**RE: Woodmen Hills Metropolitan District  
Lift Station #1 Replacement  
Administrative Plot Plan**

Add PCD File No. PPR1841

WOODMEN HILLS METROPOLITAN DISTRICT
LIFT STATION #1 REPLACEMENT
LANDSCAPING PLAN & NOTES

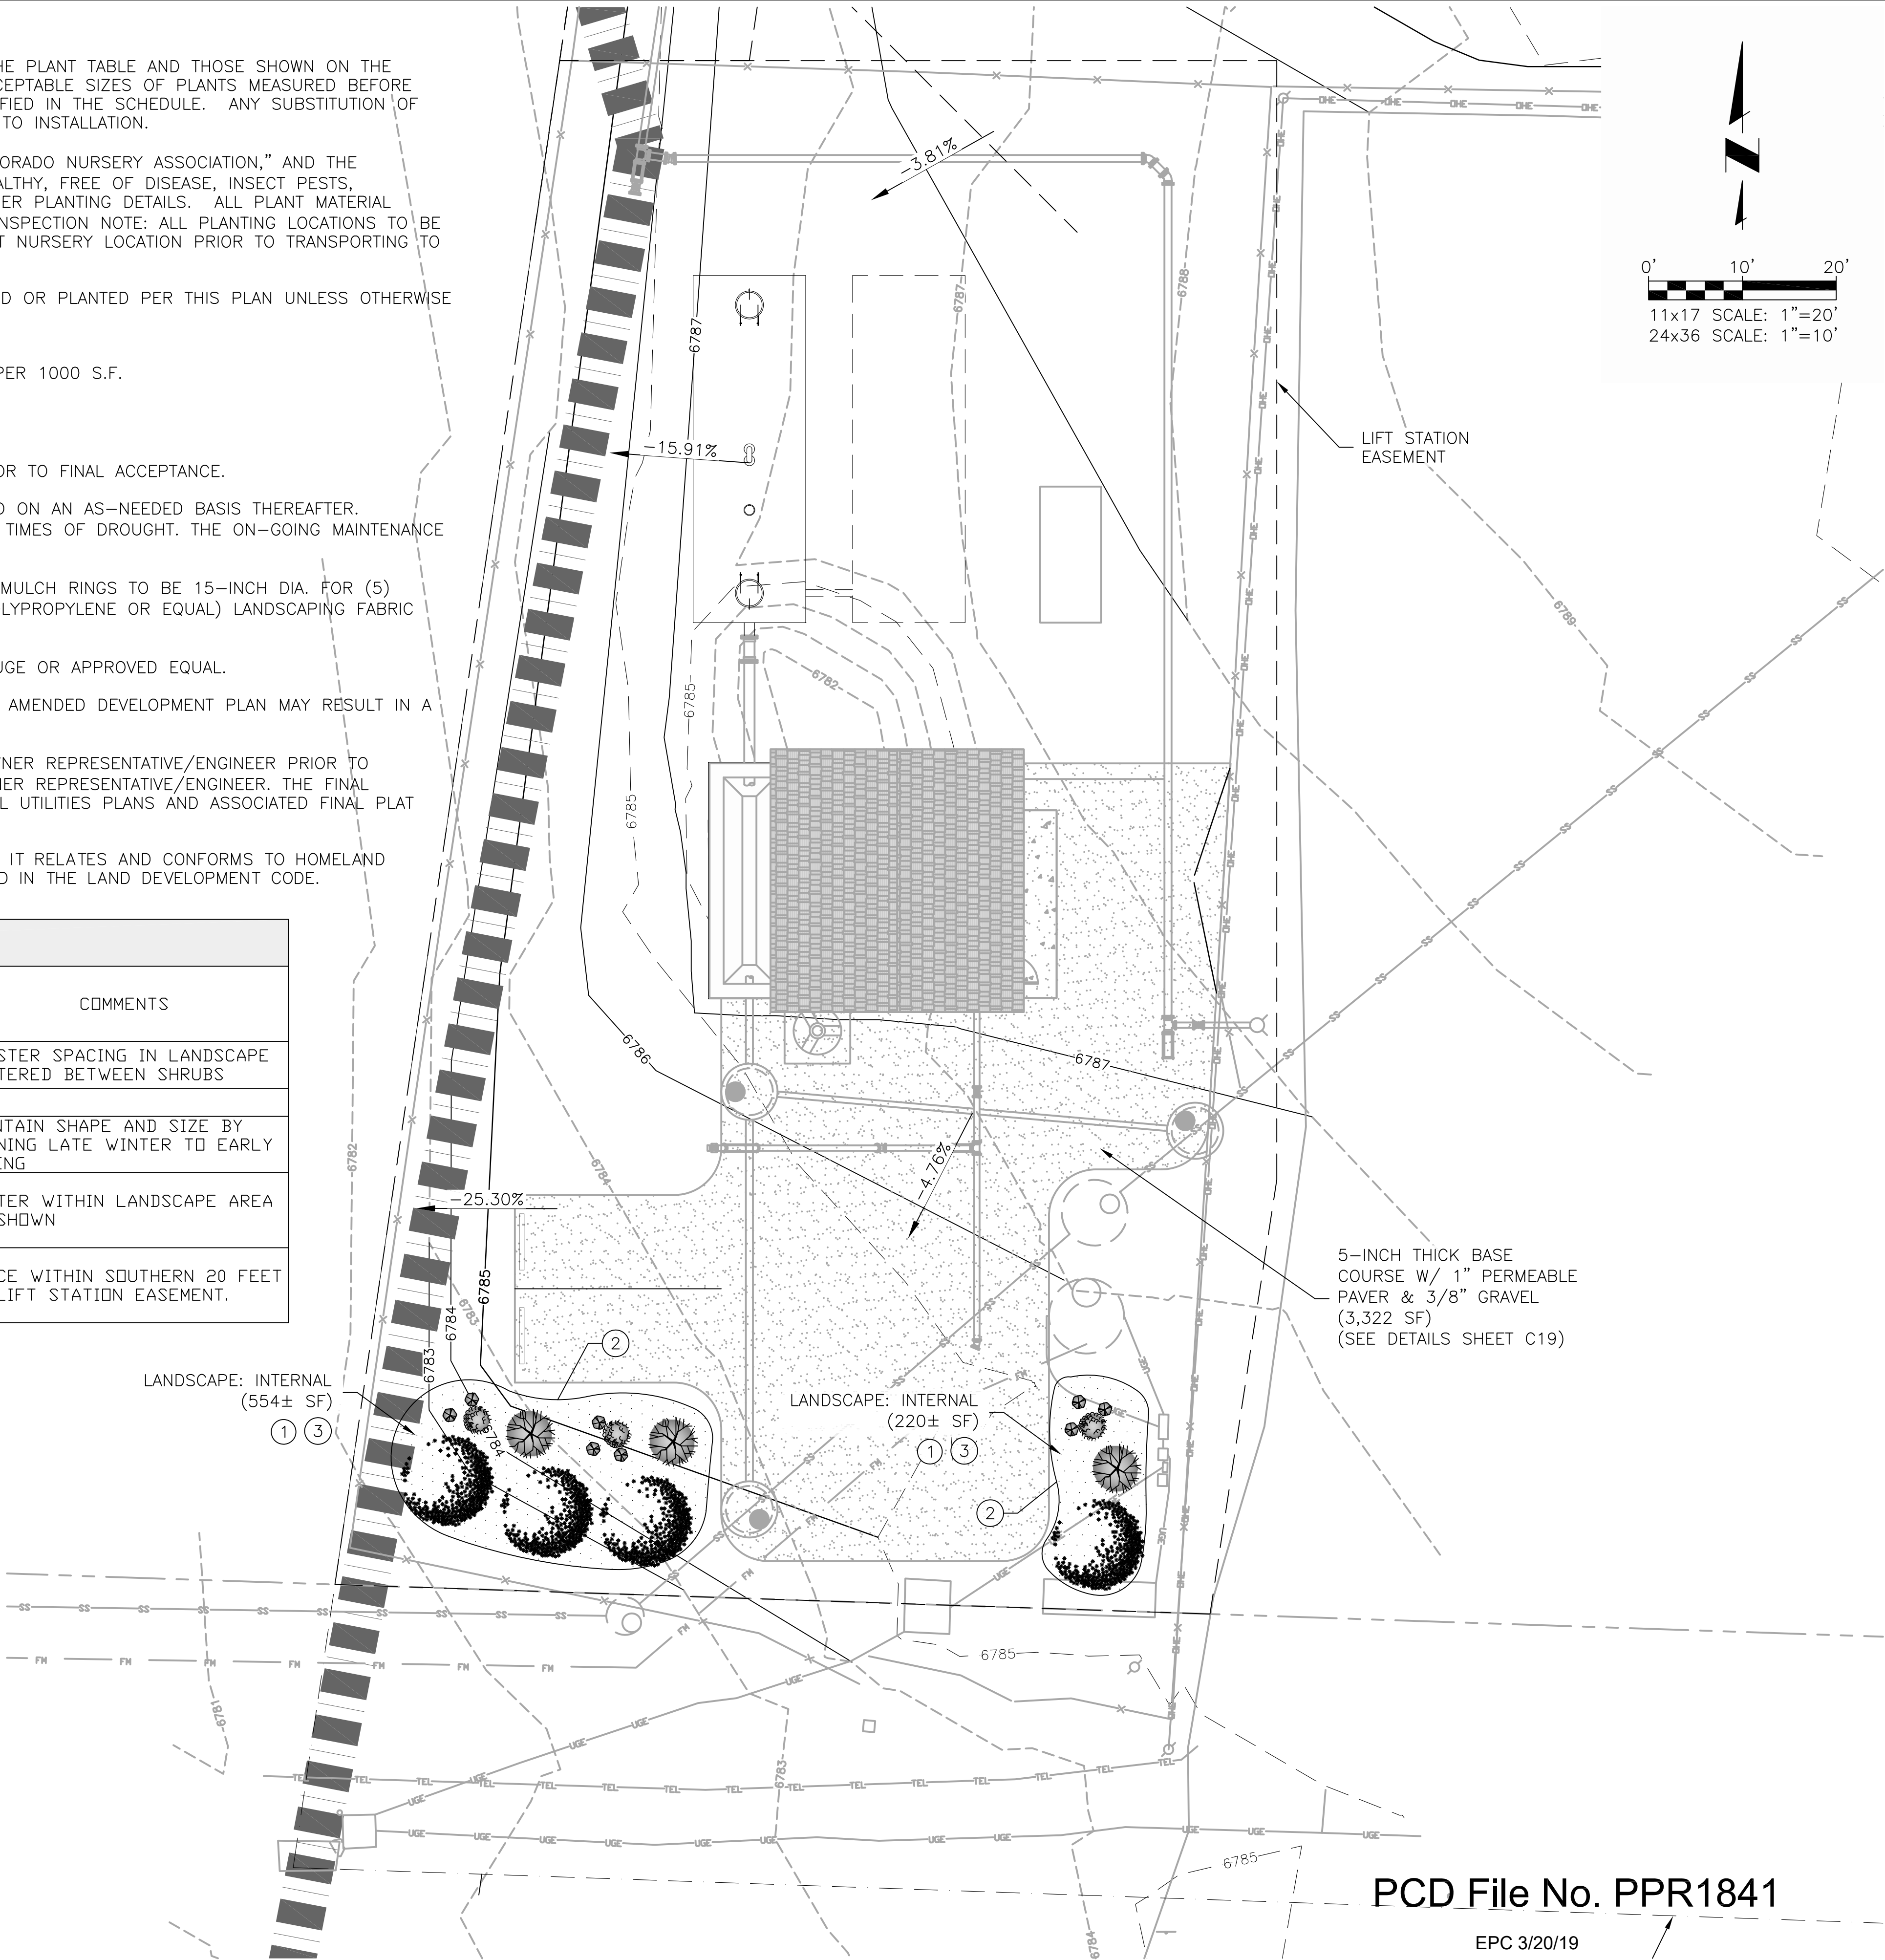
Include in here where vehicles will be parked when there are workers at the facility.

Include in here where vehicles will be parked when there are workers at the facility.
